From: Richard Castro-Parker
Sent: 04 March 2019 12:15
To: Planning.Responses
Cc: Juan Baeza
Subject: FW: M/1/19/NMA - 25 Sea Way, Middleton on Sea.
Attachments: Prop Front Elevation.pdf; Prop SF Plan.pdf

From: Chris Moore [REDACTED]
Sent: 28 February 2019 08:33
To: Richard Castro-Parker
Cc: 'Sam Donovan'; Juan Baeza; Daniel Vick; Planning
Subject: M/1/19/NMA - 25 Sea Way, Middleton on Sea.

PROPOSED SECOND FLOOR PLAN

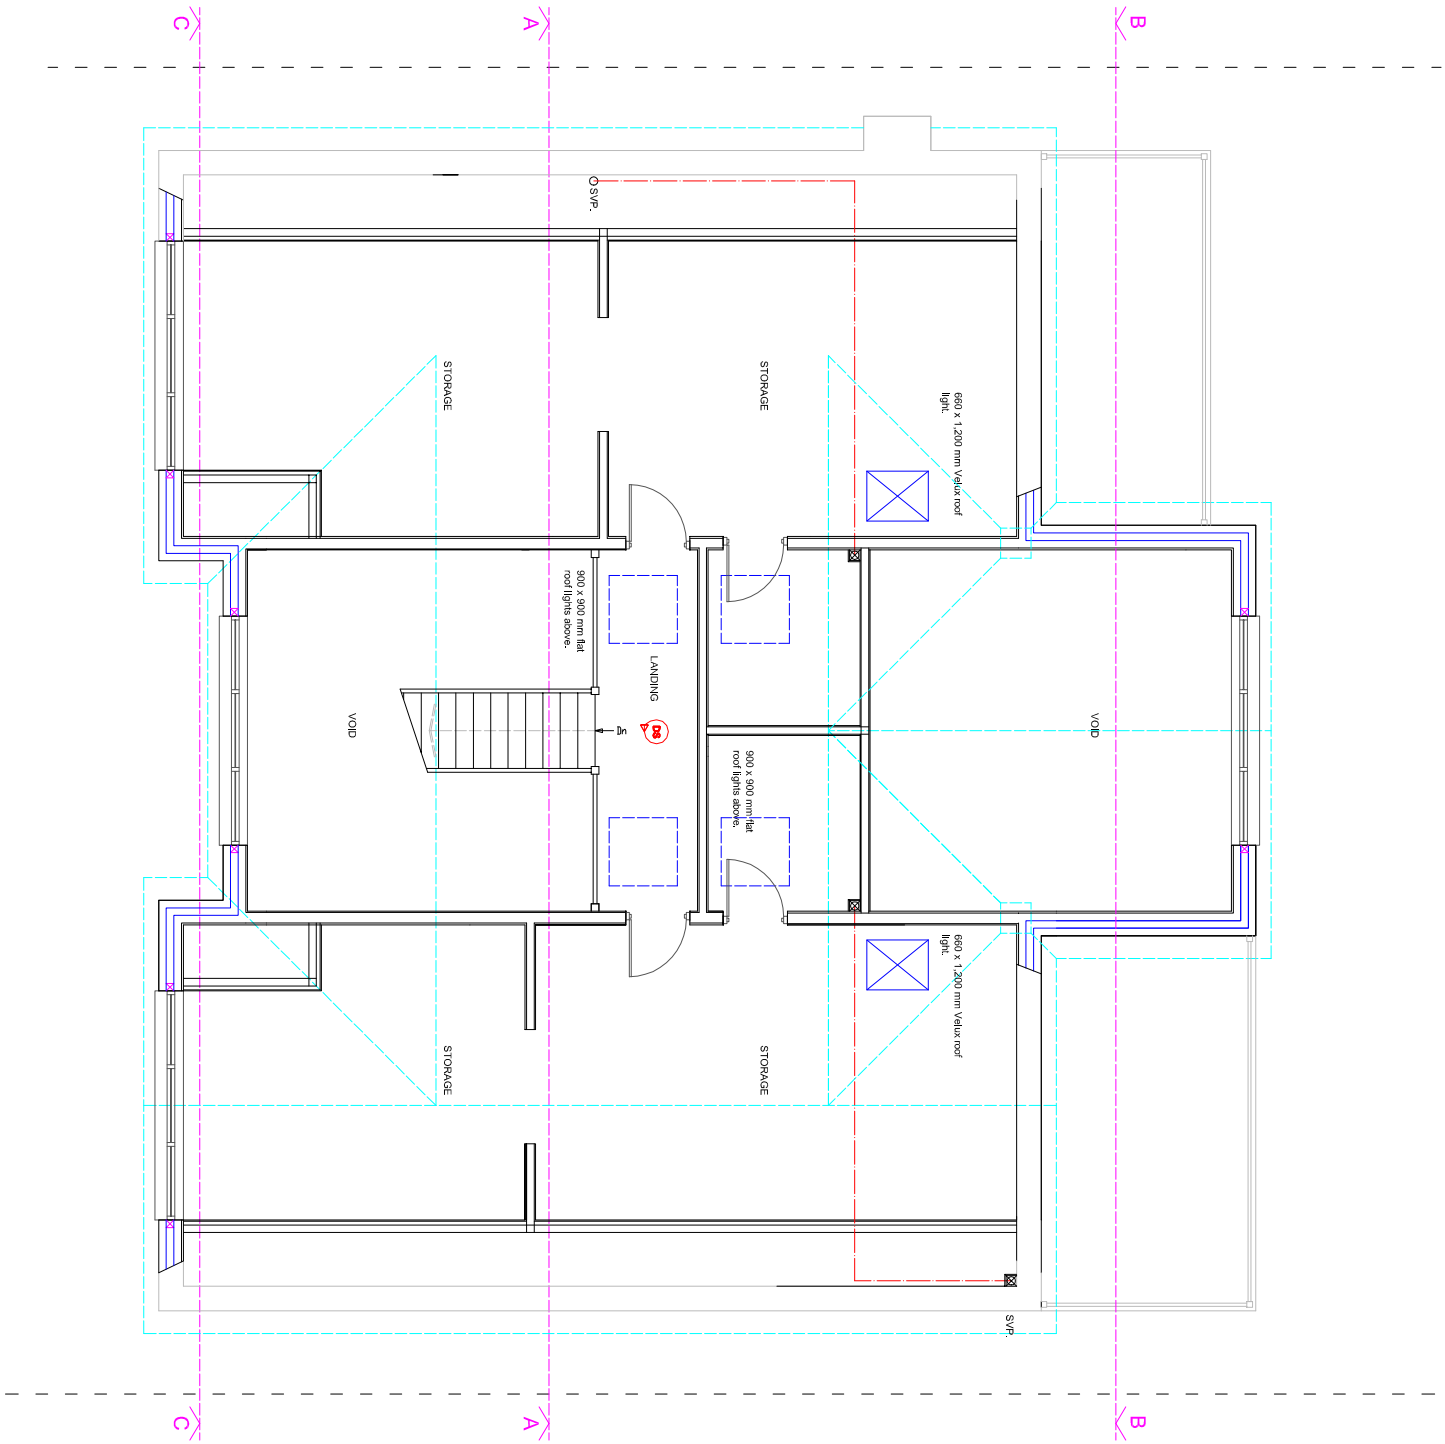
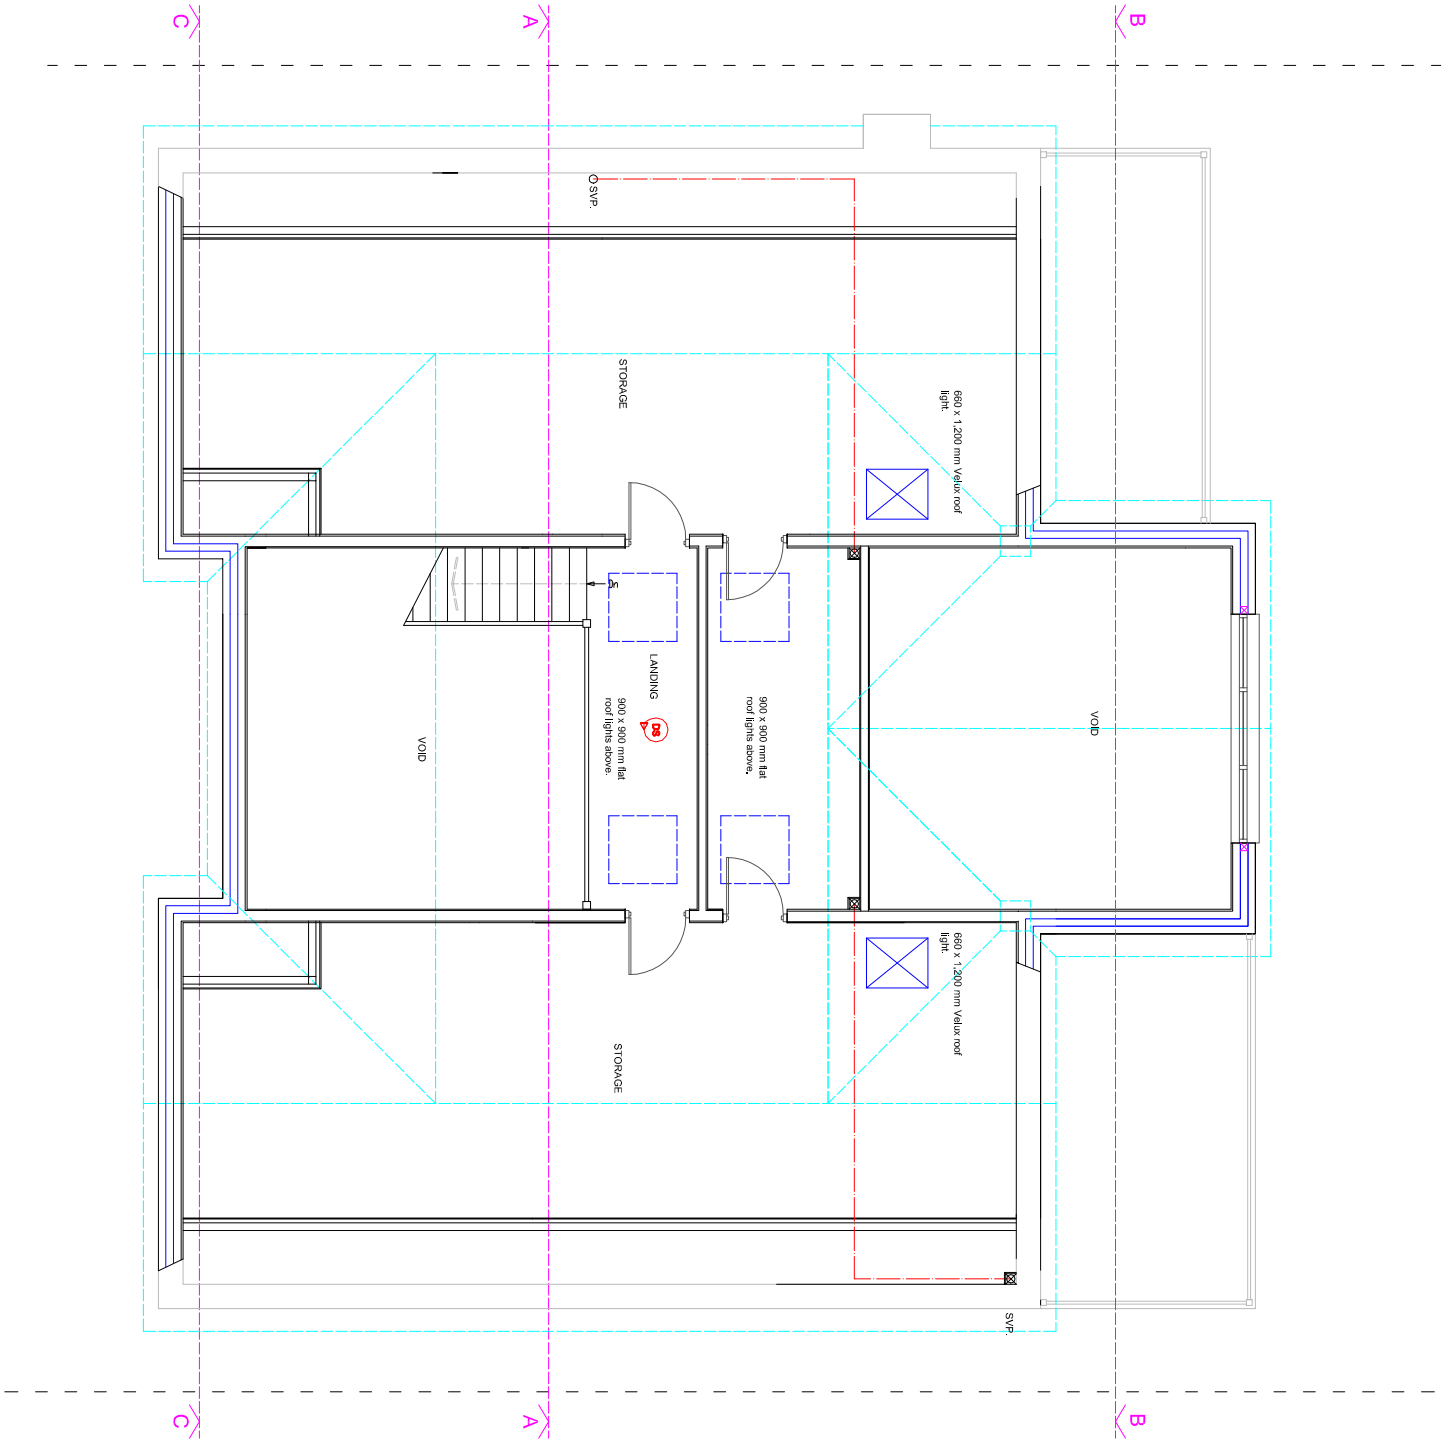
I refer to the above application and I have seen that you left a message for me yesterday. You have mentioned the fact that the submitted second floor plan shows the windows (in error) to the front facing elevation.

You have asked this question before and I have already sent you revised plans by email on 8th February and again on 14th February (after you asked again), correcting the error.

I once again attach a copy of the revised second floor plan and the front facing elevation for substitution for those you are wrongly showing on the current application.
